**SITE 43/44, SYDNEY OLYMPIC PARK
 DESIGN EXCELLENCE COMPETITION
 JURY REPORT – 23/08/10**

Executive Summary

scale	1:100	drawing no.	DA-1A-2020
drawn	DH	checked	AT
project no.	090086	issue	B

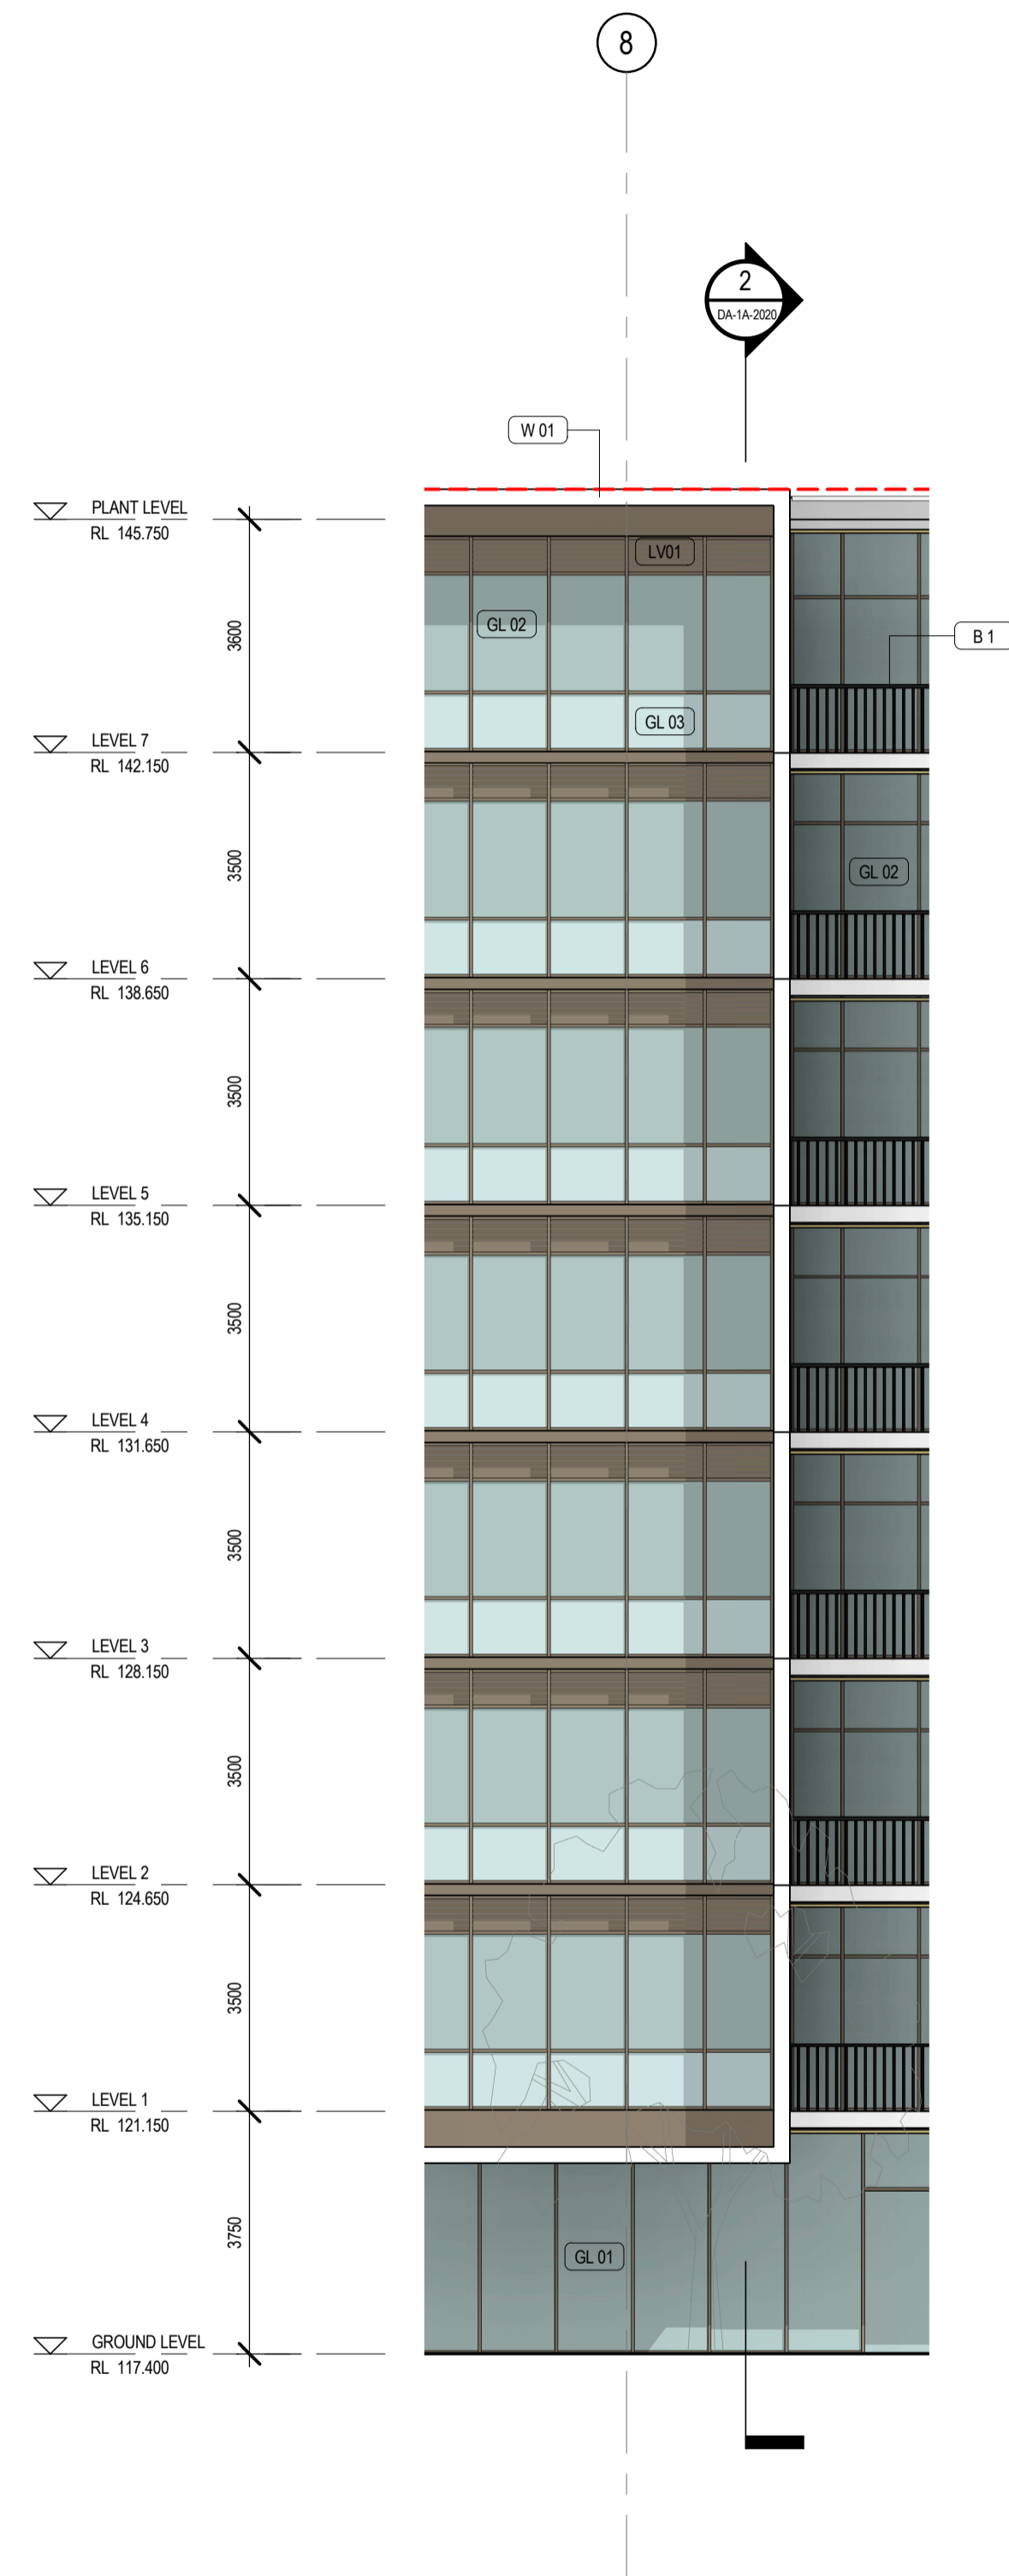
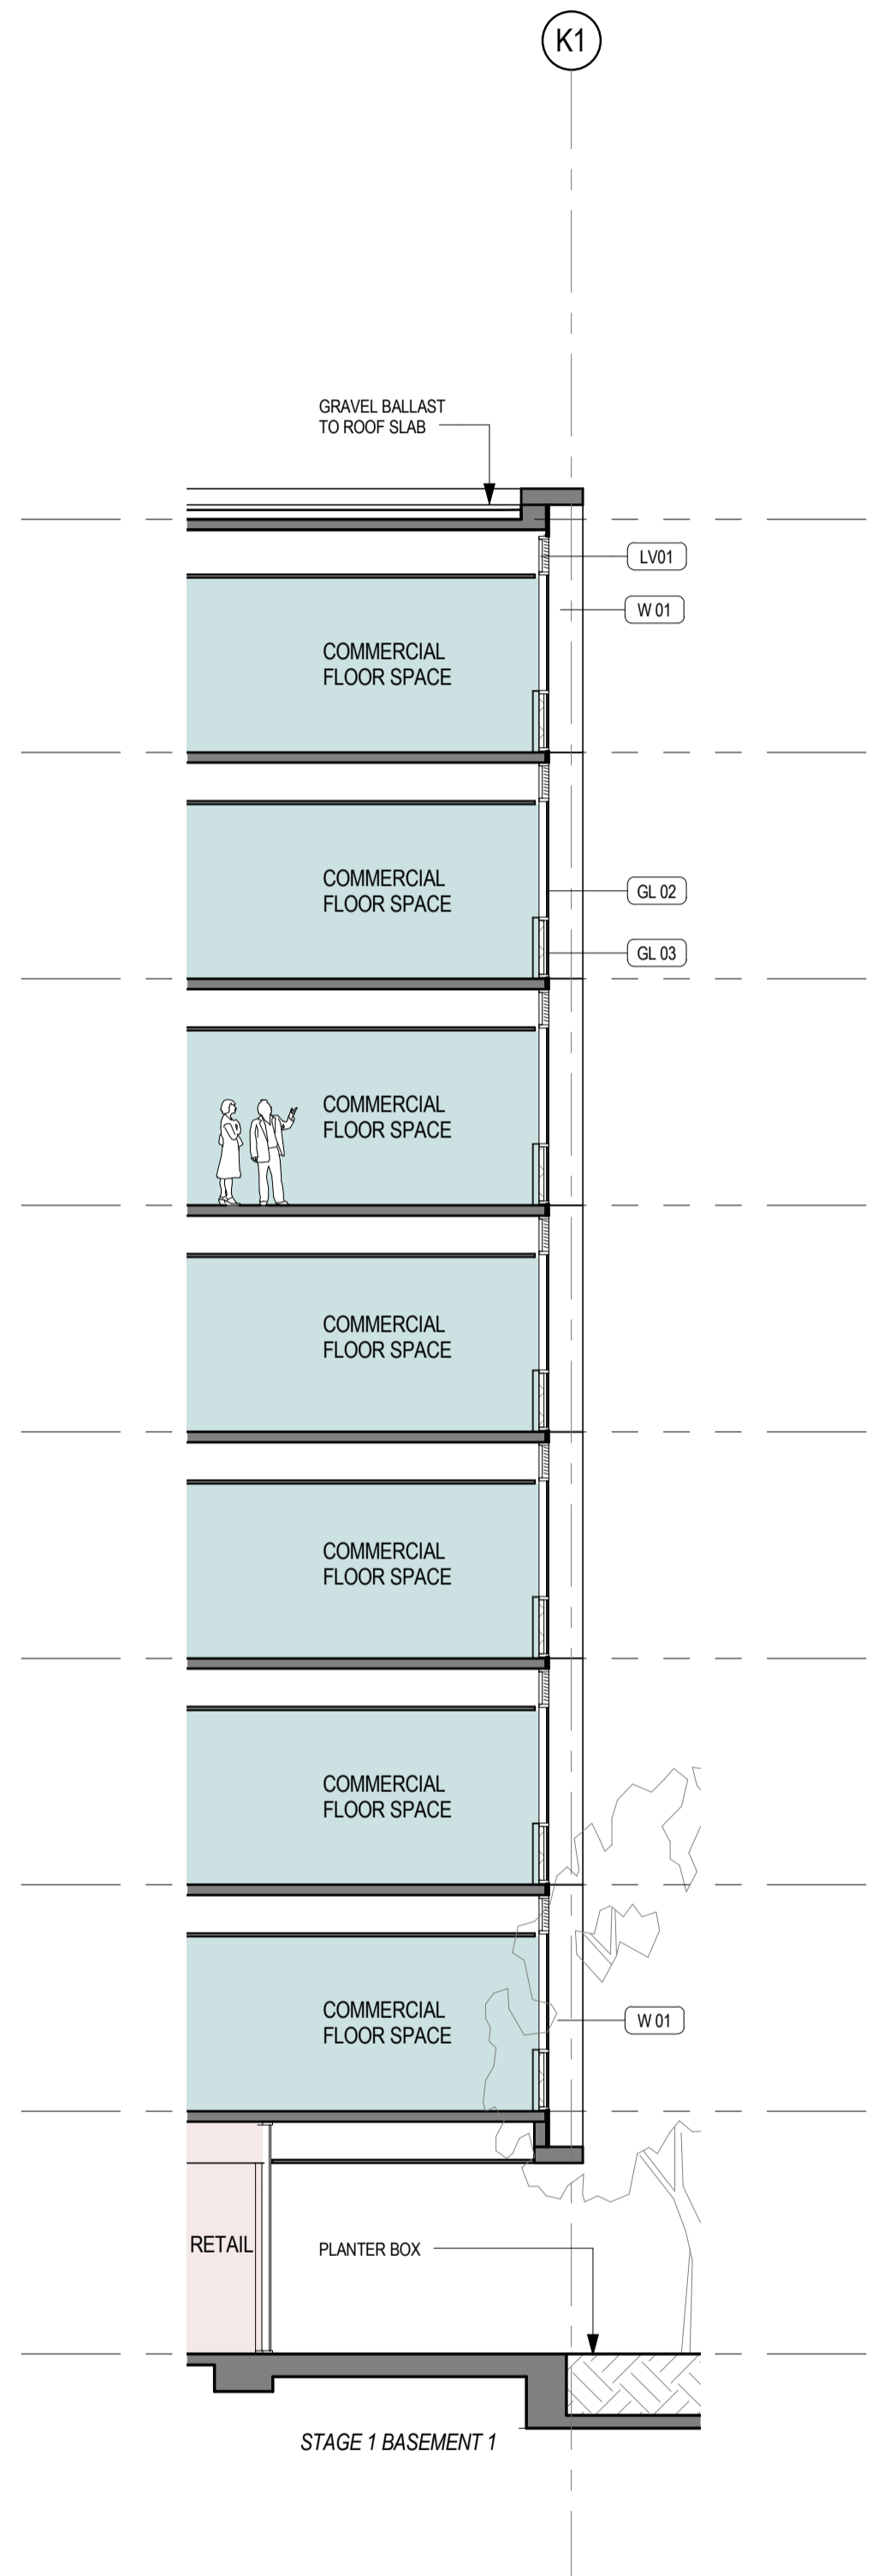
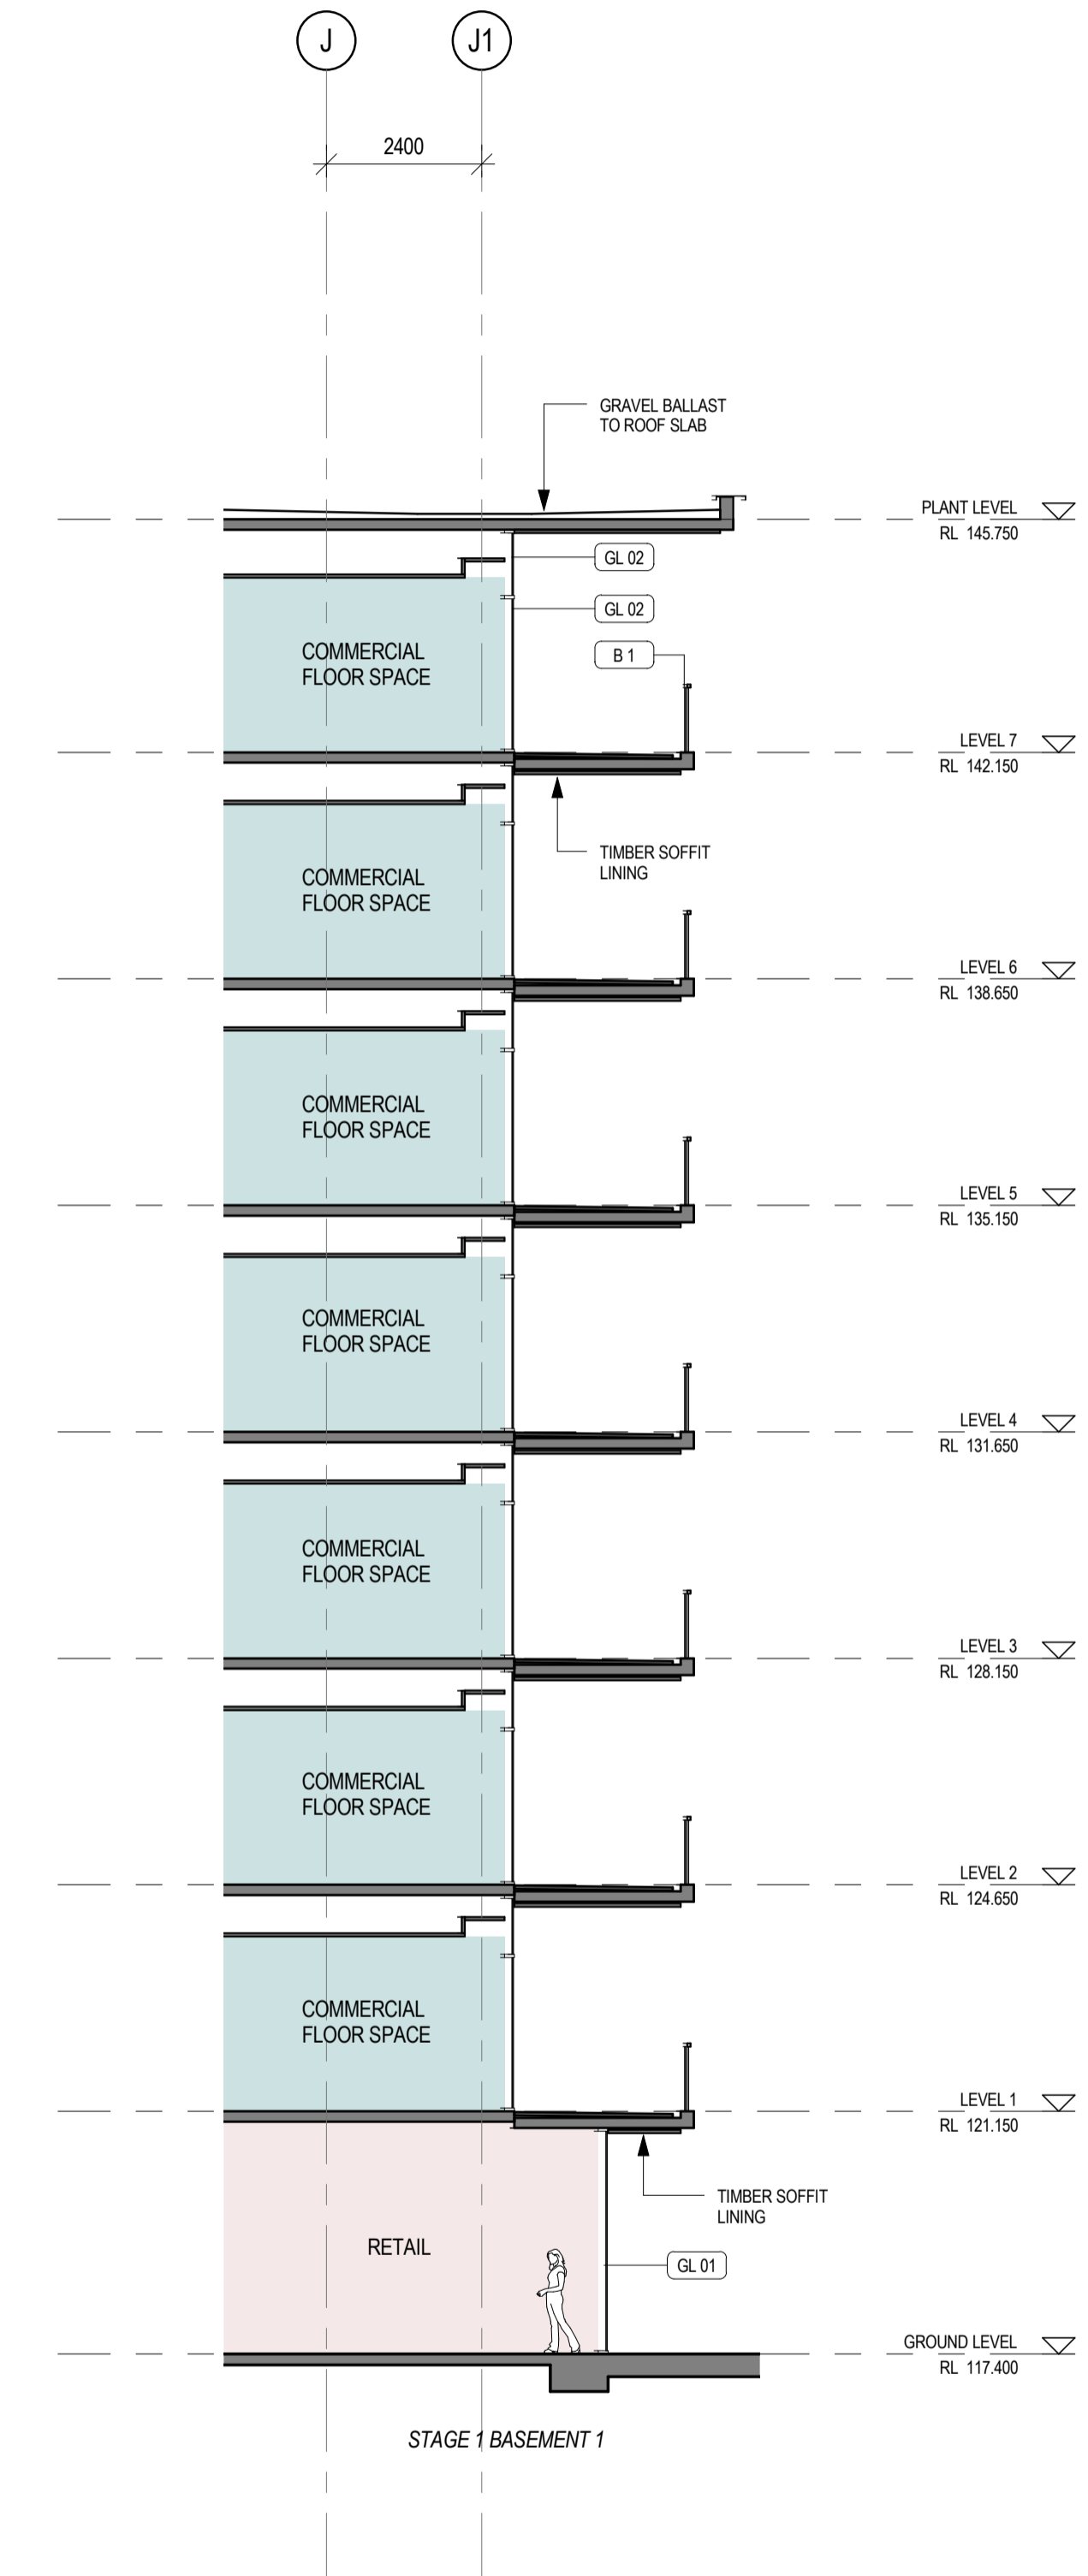
- The design submission for the overall volumes of the development however feel that the façade treatment needs further consideration.
- The inclusion of the large atrium and associated balconies which will provide vibrancy throughout the commercial levels, not just the Ground Floor retail area. As this atrium is naturally ventilated and assists the air-conditioning by utilising passive exhaust there are potentially significant benefits in reduction of energy consumption.
